Consultation Response from: KC Environmental Health (Pollution & Noise Control)
2026/91913 adj, 315, Wakefield Road, Lepton, Huddersfield, HD8 0LX

Discharge of details reserved by conditions 6 (CEMP: Biodiversity), 7 (Phase I Desk Study Report), 8 (Phase II Intrusive Site Investigation Report), 9 (Remediation Strategy), 10 (Phase II Intrusive Site Investigation Report), 11 (Verification Report), 12 (coal mining activity), 13 (materials), 14 (lighting), 15 (noise), 17 (boundary treatment), 18 (landscaping), 19 (refuse), 20 (bat box) on previous permission 2025/91961 for demolition of existing buildings and erection of detached dwelling and associated works

Responding Date:
04/09/2026

Responding Ref:
WK202626126

Exploratory Hole Location Plan

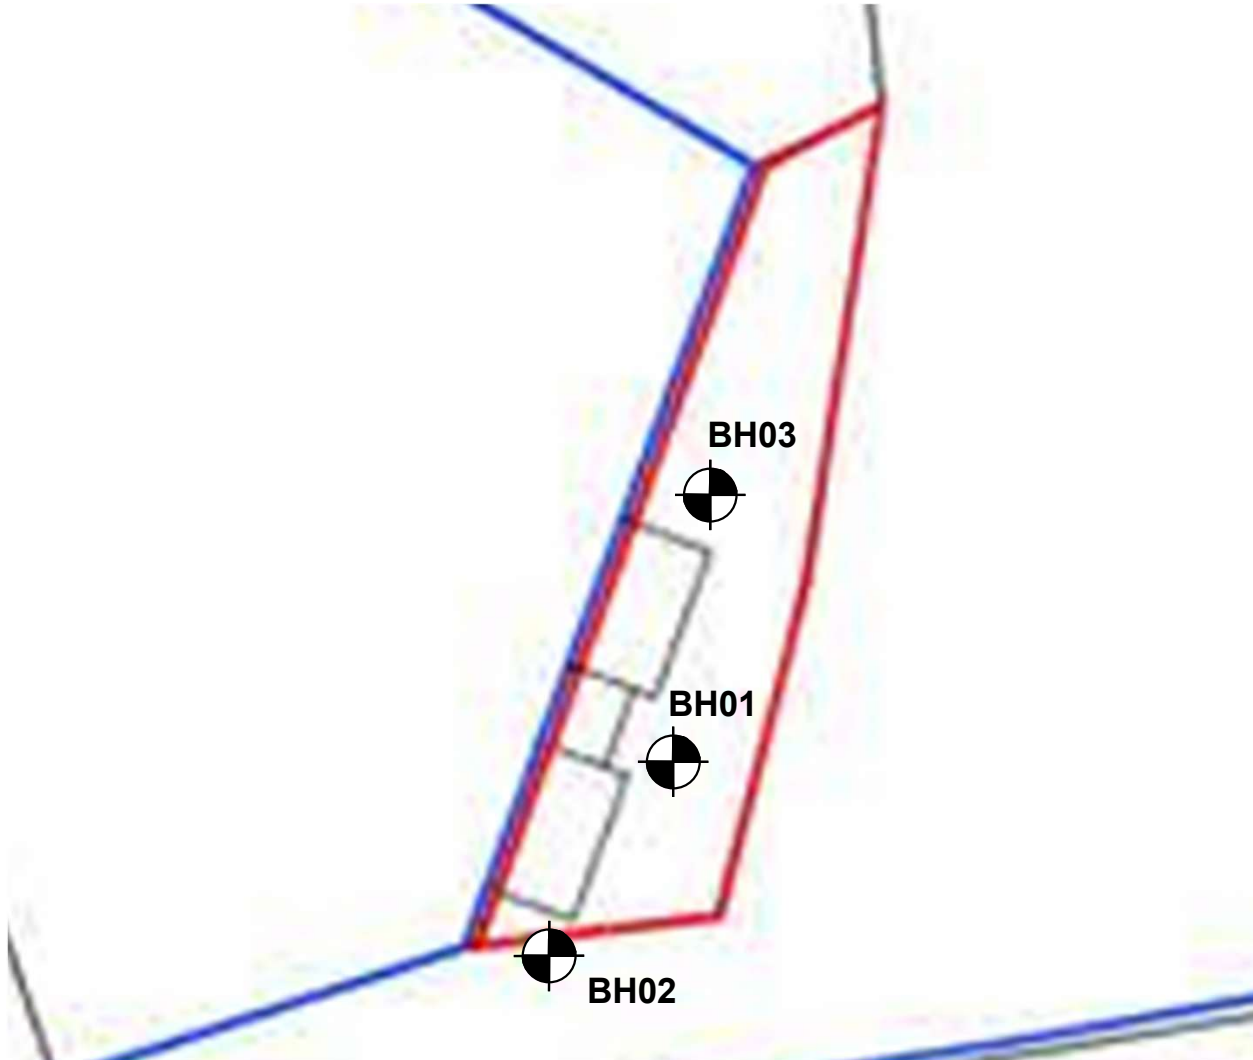
Environmental Health has concerns regarding the extent of the contamination investigation and the rationale used to develop the sampling strategy. The original Phase I identified the existing maintenance/storage buildings as potential contamination sources, yet there is insufficient evidence within either the original Phase I assessment or the submitted Phase II report to demonstrate that the investigation was designed around these identified source areas. Furthermore, the environmental assessment is based on only four laboratory samples, predominantly shallow topsoil samples, and no clear justification has been provided to demonstrate that sampling locations were selected to target the potential contamination sources previously identified within the conceptual site model.

Environmental Health also notes that the ground gas assessment is based on only three monitoring rounds over a three-week period. Whilst the report concludes that the site is Characteristic Situation 1 (CS1), the monitoring data include carbon dioxide concentrations of up to 2.8% v/v and oxygen depletion to as low as 12.7% v/v. The lowest recorded atmospheric pressures occurred during rising pressure trends, whereas the highest carbon dioxide concentration and highest recorded flow rate occurred during a falling pressure event. The report provides limited discussion regarding the significance of the observed oxygen depletion and whether the monitoring period is sufficiently representative of worst-case gas migration conditions especially given the uncertainty regarding shallow mine workings at the site.

On the basis of the information submitted, Environmental Health is not satisfied that the requirements of Condition 7 have been met. A revised Phase I Preliminary Risk Assessment should be submitted addressing the concerns previously raised by Environmental Health and providing an updated conceptual site model. We are unable to recommend discharge of Condition 7 at this time.

Until a revised Phase I Desk Study Report has been reviewed and agreed, we consider it premature to determine whether the submitted Phase II Intrusive Site investigation has been appropriately designed and whether the reported findings are sufficient to characterise the contamination and ground gas risks associated with the site. We would recommend that Condition 8 remain at this time.
